Addendum No. 2

RE: Contract # C204507

Cumberland County (U-5798A)

SR-1102 FROM NORTH OF SR-1112 TO US-401 AND REPLACE BRIDGE
250075 OVER LITTLE ROCKFISH CREEK.

JOINT DETAIL
REINFORCING STEEL NOT SHOWN FOR CLARITY

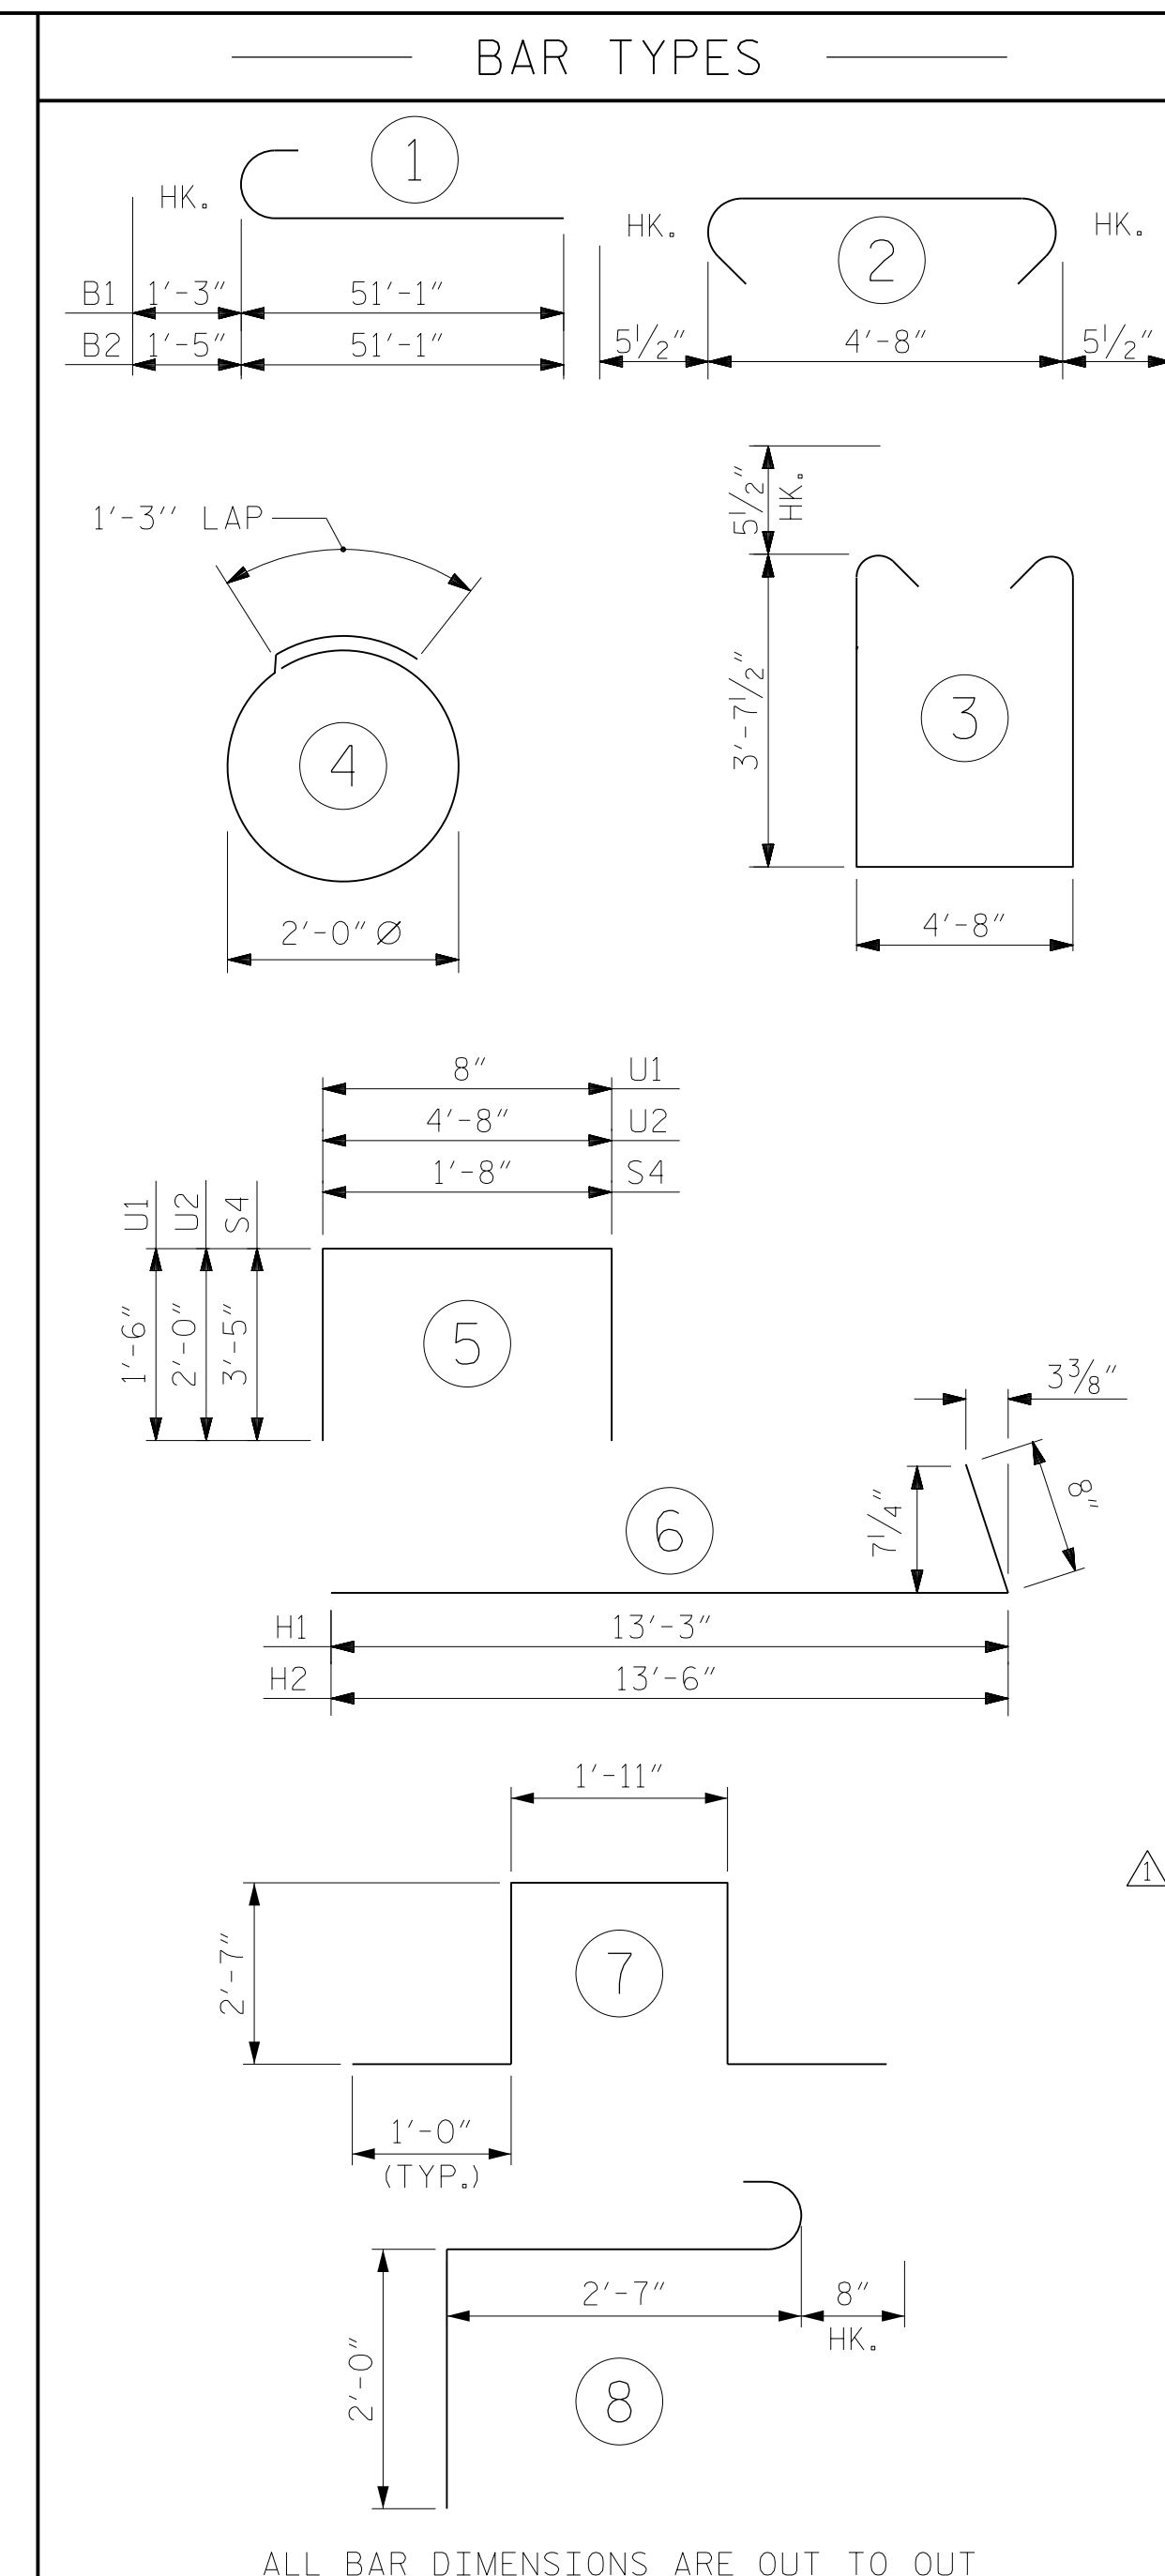
Sheet No.	Revision
S1-3	Updated to reflect quantity changes.
S1-33	Updated to reflect quantity changes.
S1-39	Updated to reflect quantity changes.
S2-3	Updated to reflect quantity changes.
S2-33	Updated to reflect quantity changes.
S2-39	Updated to reflect quantity changes.

<u>Item</u>	<u>Description</u>	<u>Old Quantity</u>	<u>New Quantity</u>
0240-8328200000-E-450	PILE DRIVING EQUIPMENT SETUP FOR HP 14 X 73 STEEL PILES	40 EA	44 EA
0242-8384000000-E-450	HP 14X73 STEEL PILES	2,580 LF	2,840 LF
